CITY OF PORTLAND, MAINE
HISTORIC PRESERVATION COMMITTEE

Re: 208 Danforth Street – exterior alterations

On October 2, 2002, the City of Portland's Historic Preservation Committee voted 6-0 (Hobler absent) to approve your application for a Certificate of Appropriateness for exterior alterations at 208 Danforth Street. Approval is for removal of an existing fire escape and construction of a one-story open porch on the same footprint; modifications to window and door openings; and replacement of the porch on the rear ell.

PROPOSED DECK:

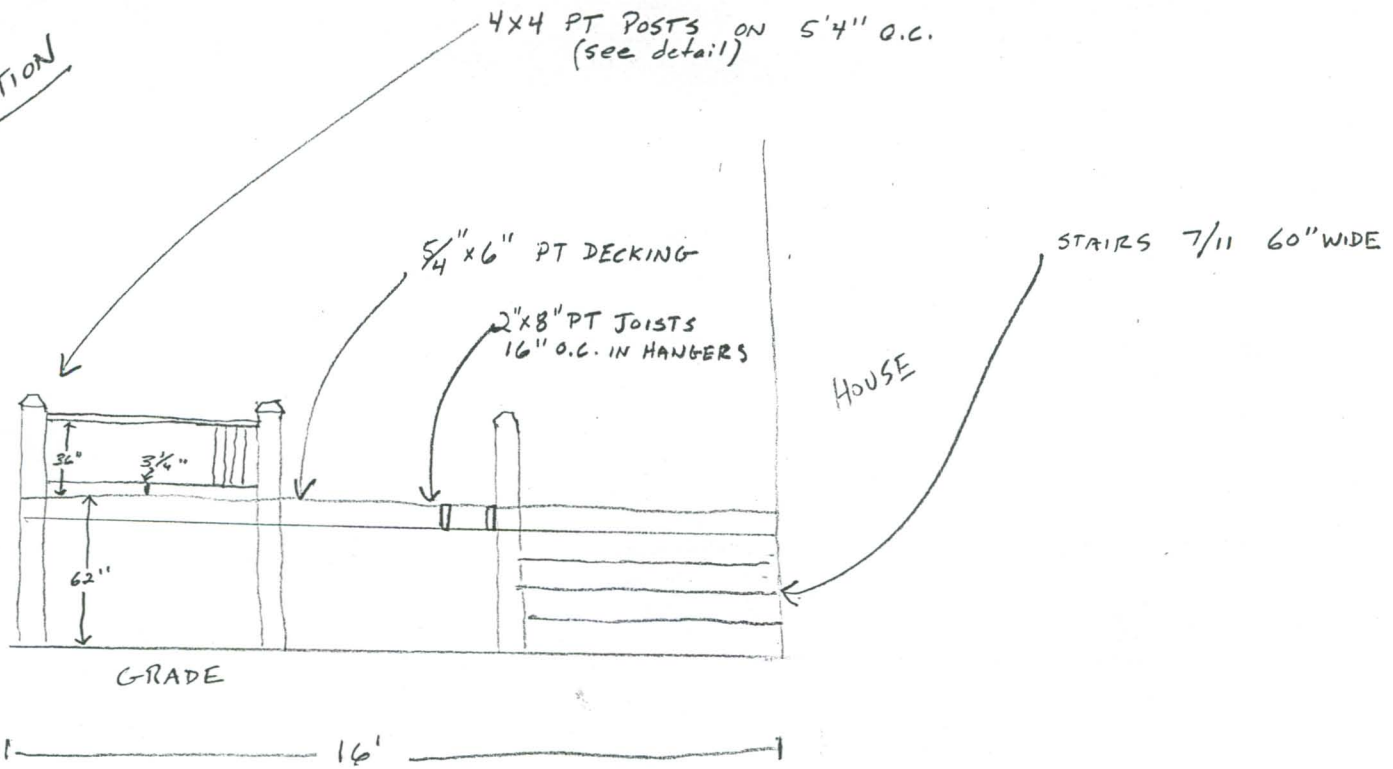
- In regard to the shortened window opening on the rear elevation, the lower half of the existing opening shall be infilled with a wood panel. This panel shall be recessed from the wall plane to preserve the original opening. Final details of this alteration to be submitted for staff review and approval.
- The replacement window for this window opening shall be a 6-lite casement or awning window.
- Details for both rear porches shall follow specifications outlined in excerpted *Guidelines for Porch Repair & Replacement*.
- Skirting below both porches shall be fully framed.
